DEVELOPMENT REVIEW BOARD
SUPPLEMENTAL SUBMITTAL

PROJECT NO. PR-2021-006238

Application No. SI-2021-01916

Re: Allaso Louisiana Site Plan – DRB Comment Responses (PR-2021-006238)

DRB SITE DEVELOPMENT PLAN APPROVAL:

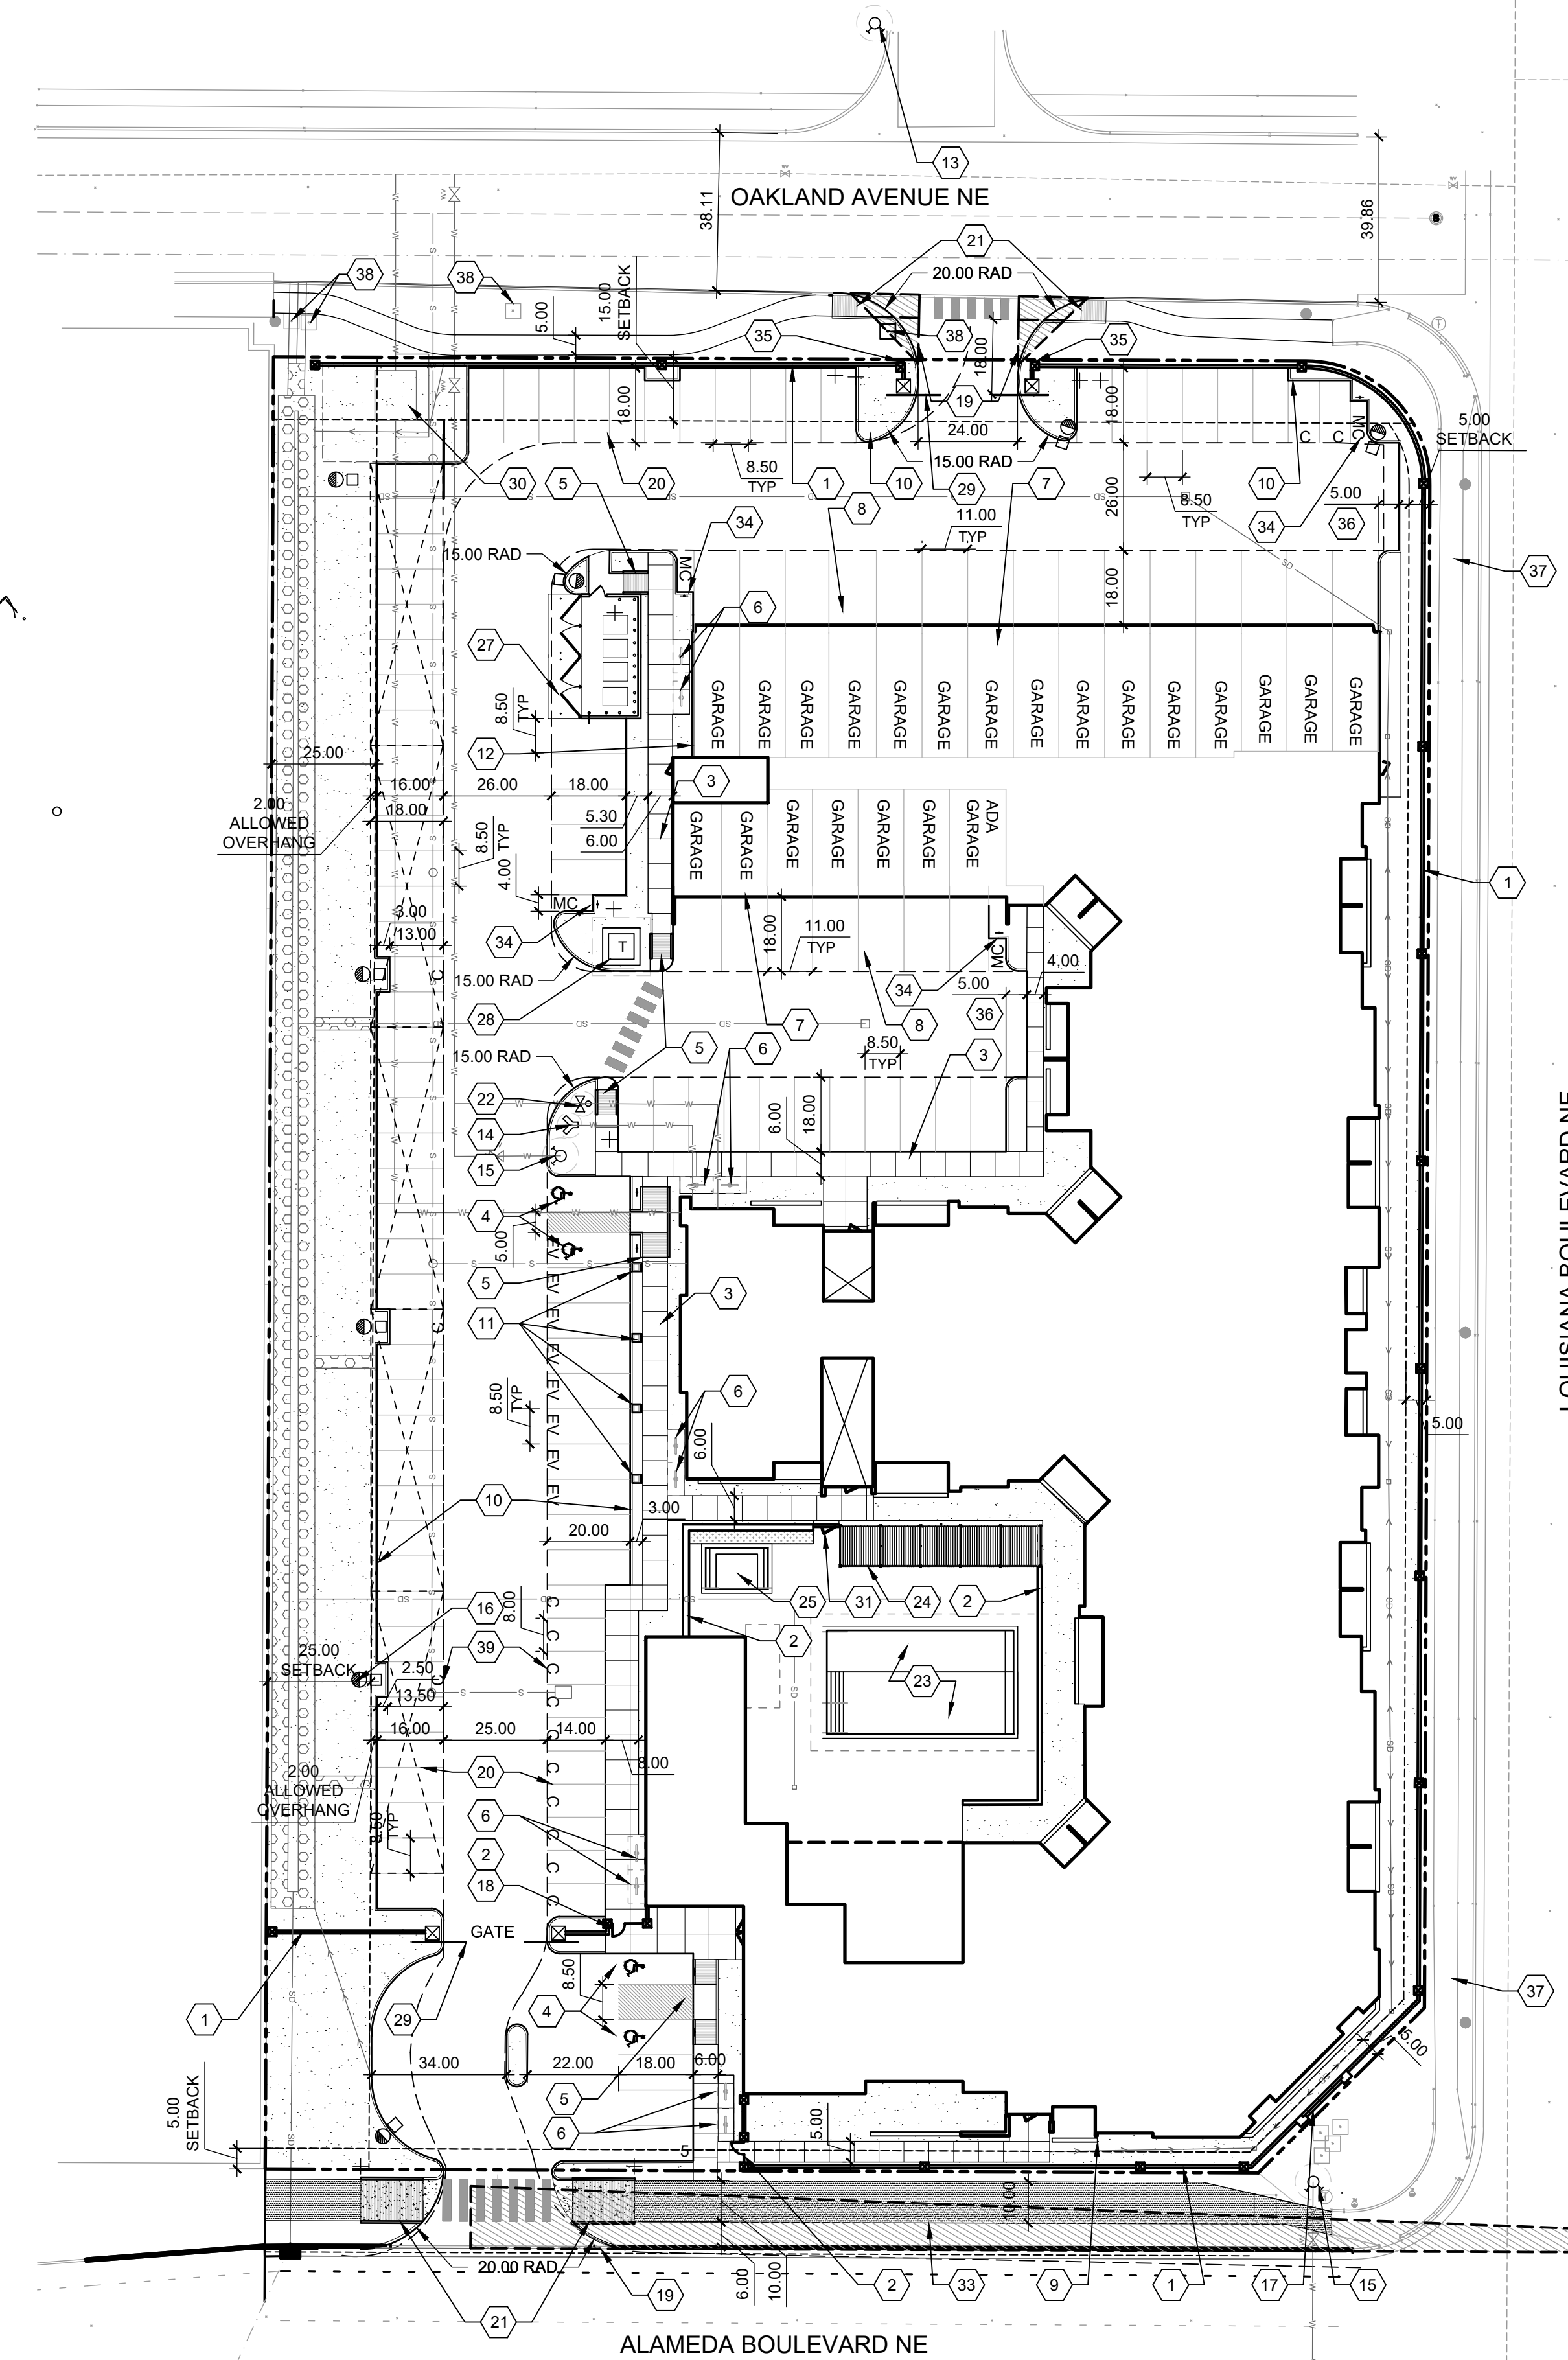
4. Clarify buffering area provided on the West side of property separating area of change and consistency.
 - a. ***This buffer is dimensioned, as well as identified with Keynote #16 clearly showing the 25-foot width.***

1. For Alameda Boulevard, due to speed limit, the clear sight triangle should represent intersection sight distance. Reflect on landscape plan.
2. For the clear sight triangles shown on Oakland, project triangle all of the way to the curb line.

10. Label a 5-foot parking lot keyway at the end of the parking lot for both locations where applicable.
11. The parking lot in the middle of the site plan should show a crosswalk to complete the ADA pathway. The curb ramp on the far north side does not lead to any continuous pathway to the north and appears to not be needed since the ADA connection to the right-of-way is to the south.

13. Call out all public sidewalk widths and landscape buffer widths on site plan. All new public roadway infrastructure shall be placed onto an infrastructure list.

- a. ***The clear sight triangles for both entrances have been updated on the Site Plan and Landscape Plan, as requested.***
3. Typically, the City of Albuquerque would request a turn-around or a decel lane for Oakland in addition to the one shown on Alameda Boulevard if using as ingress. There is also no space for any type of a queue before the Oakland gate. If Oakland is wide enough for two-way traffic in addition to a queue, present dimensioning on the site plan.

- a. ***Dimensioning has been added to the Site Plan showing adequate width for queueing and traffic.***
4. Provide an infrastructure list for all improvements within the right-of-way, including the proposed asphalt trail and the transit shelter.

- a. ***Keyways are dimensioned and a crosswalk has been added to complete the ADA pathway across the middle parking area.***
12. Where are motorcycle spaces shown? Also, provide motorcycle sign parking detail along with "MC" at the back of the parking space.

- a. ***Sidewalk widths are dimensioned and have been placed on the infrastructure list.***

LS-01

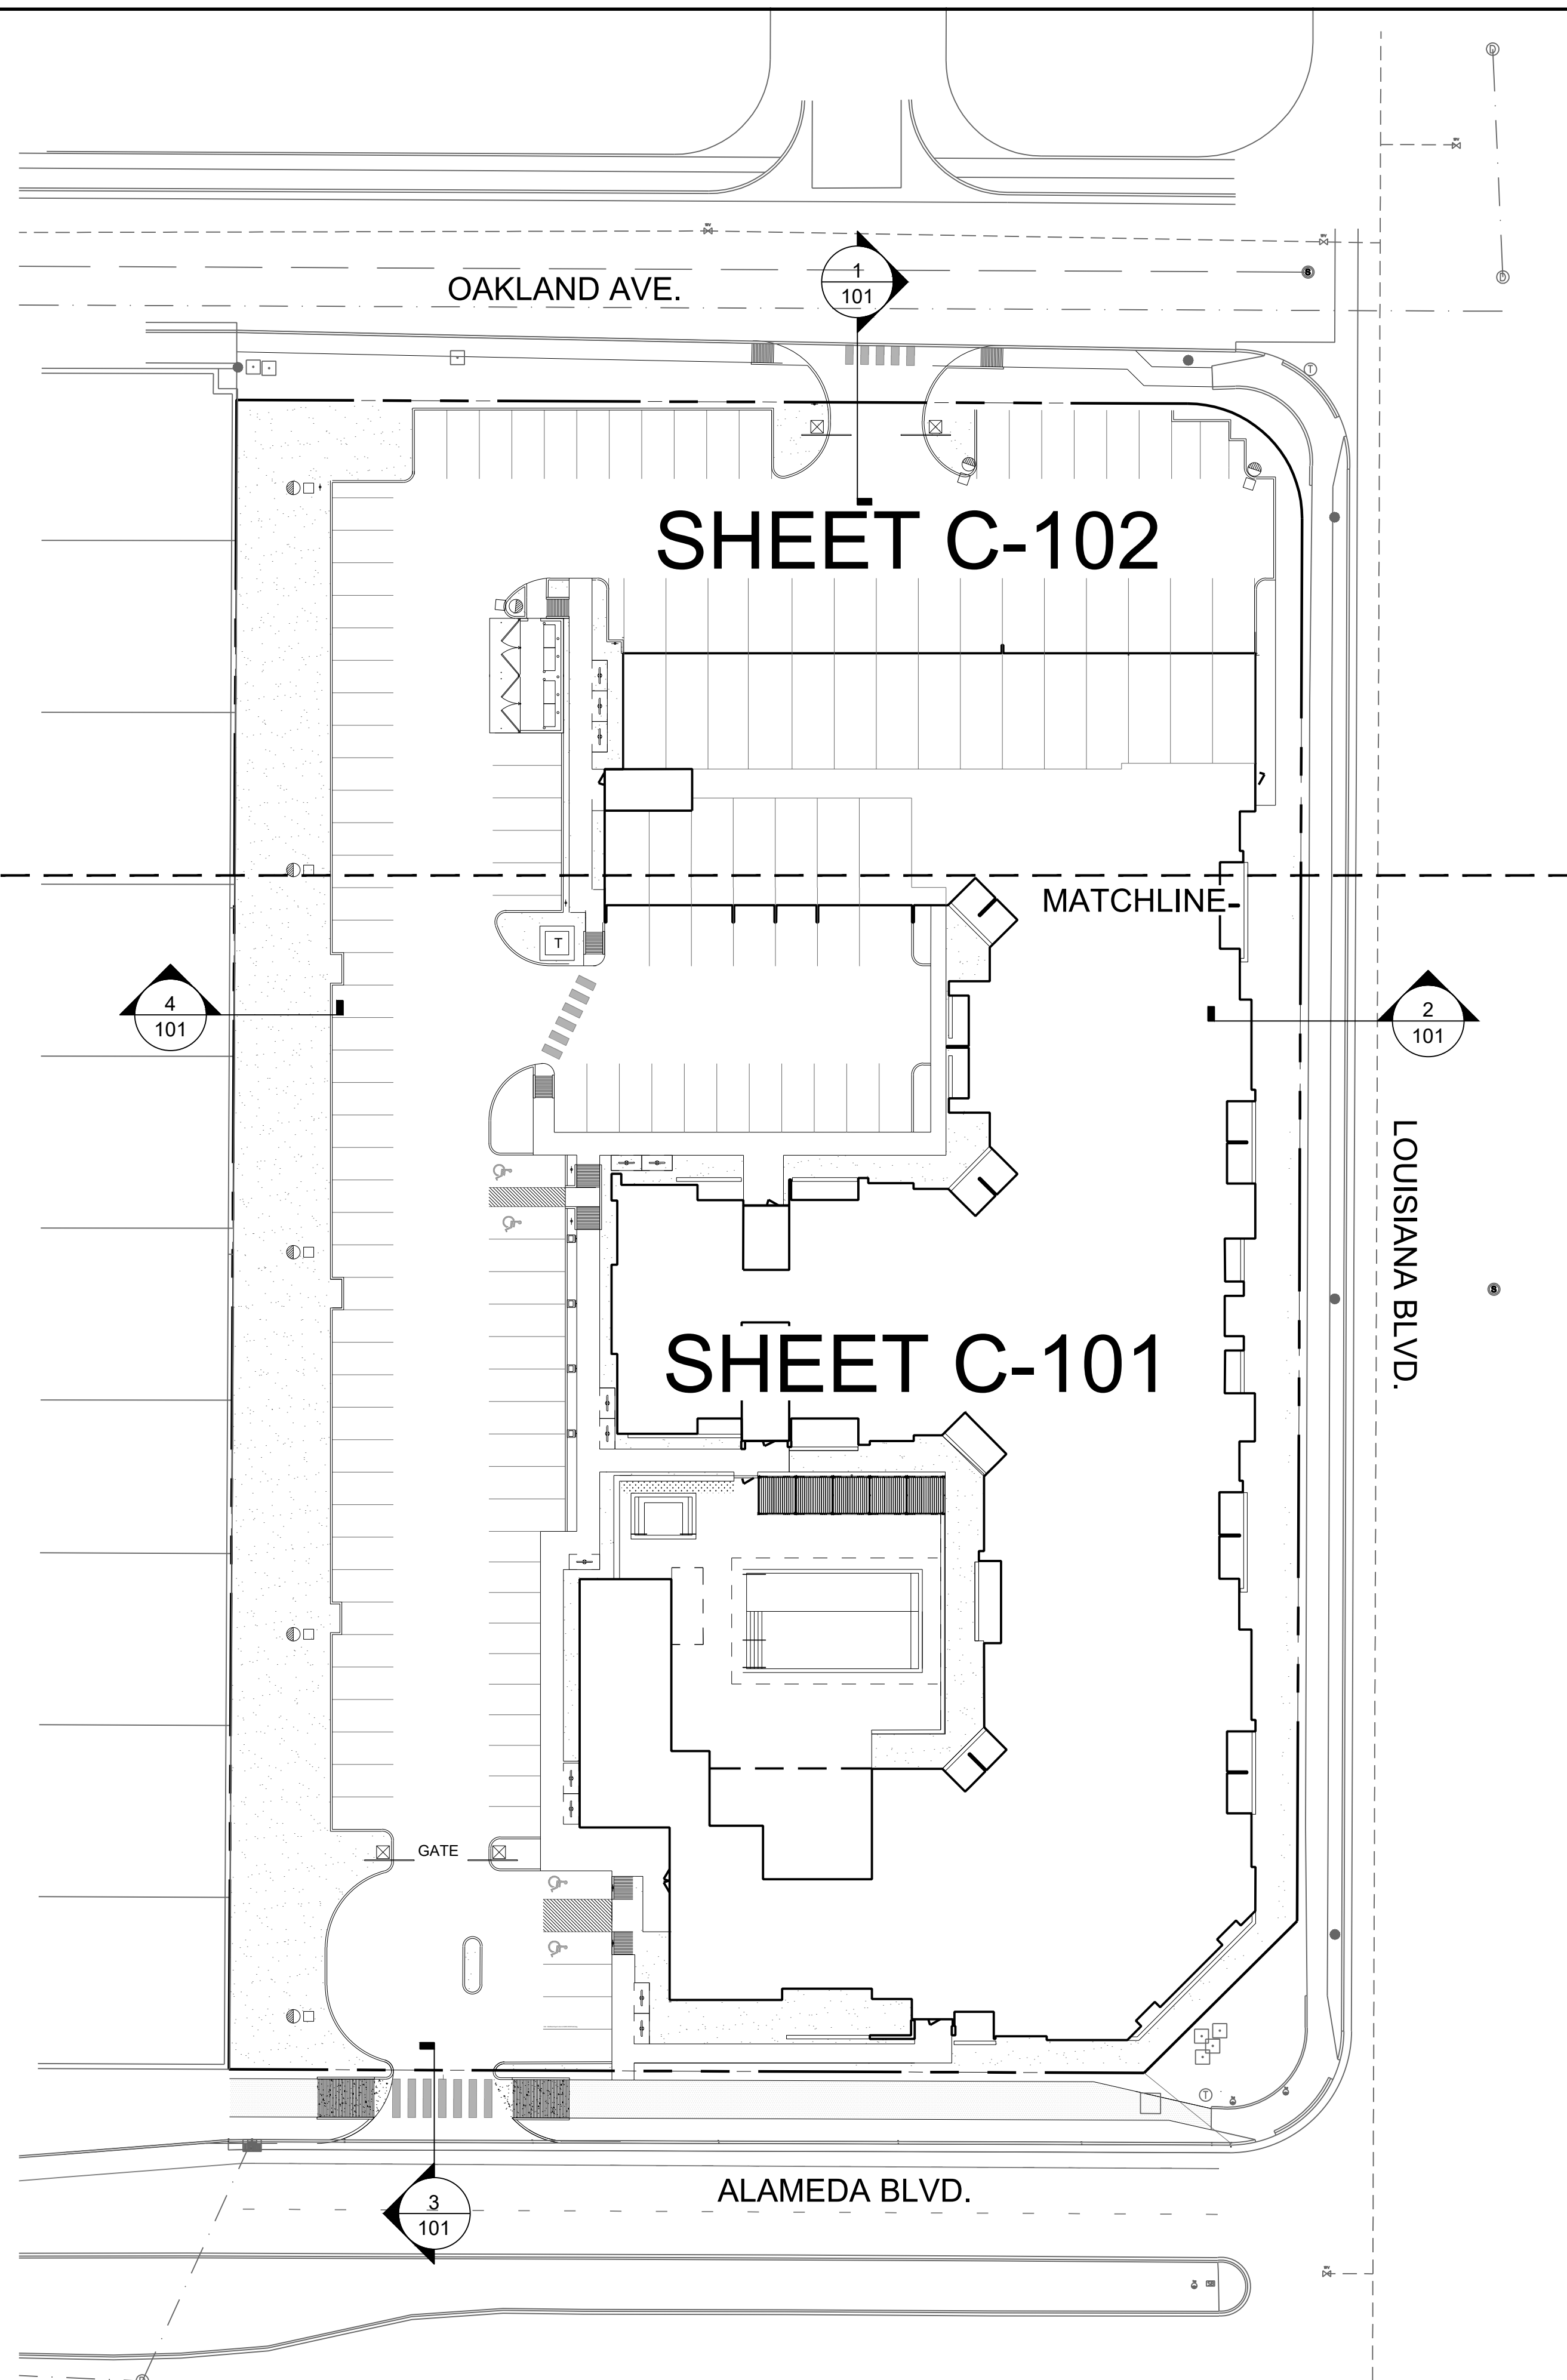
4. Utility Plan:
 - a. Please explain the proposed sand trap.
 - b. There shall be no trees, parallel fences/sidewalks/curbs, or structures within the public water and public sewer easement. Please revise landscape plan in the area of the water meter vault.

- a. **Understood.**
 3. 4-3(B)(7)(c) of the IDO pertaining to landscaping requirements including for the use-specific standards of 4-3(B)(7) for multi-family dwellings requires at least 50 percent of the trees be deciduous canopy-style shade trees or coniferous trees capable of attaining a mature canopy diameter of at least 25 feet. Confirmation needs to be provided if the shade trees on the Landscape Plan are capable of attaining a mature canopy diameter of at least 25 feet.

14. Alameda Blvd NE is a Regional Principal Arterial and Louisiana Blvd NE is a Major Collector, requiring street trees. The Parks and Recreation Department (PRD) is a partner with the Nature Conservancy who developed a Climate Ready Tree List for Albuquerque. PRD encourages developers to use this list for street trees (see insert below). Ash is not considered Climate Ready.
Lists linked here:
Trees must be recommended on the Official Albuquerque Plant Palette: [Official Albuquerque Plant Palette and Sizing List-2018-07-03.xlsx \(cabq.gov\)](#)
Please reference the CLIMATE-READY TREES FOR ALBUQUERQUE: [NMFO Climate-Ready Trees Lists \(nature.org\)](#)

- a. ***The landscape plan has been updated to remove landscaping from around the meter vault location.***
5. Infrastructure List:
 - a. No public water or sewer main extensions are required for this project.

- a. **This calculation has been added to the updated landscape plan. 34 are required to be deciduous of this size, and 35 are provided.**
 4. Please note that the 2020 IDO Update gave greater allowances for cool and warm seasons grasses for multi-family projects. Please see IDO Section 4-3(B)7 to see if there are allowances that would benefit your landscape plan.

- a. The landscape plan has been updated to replace the Ash trees with different species.**
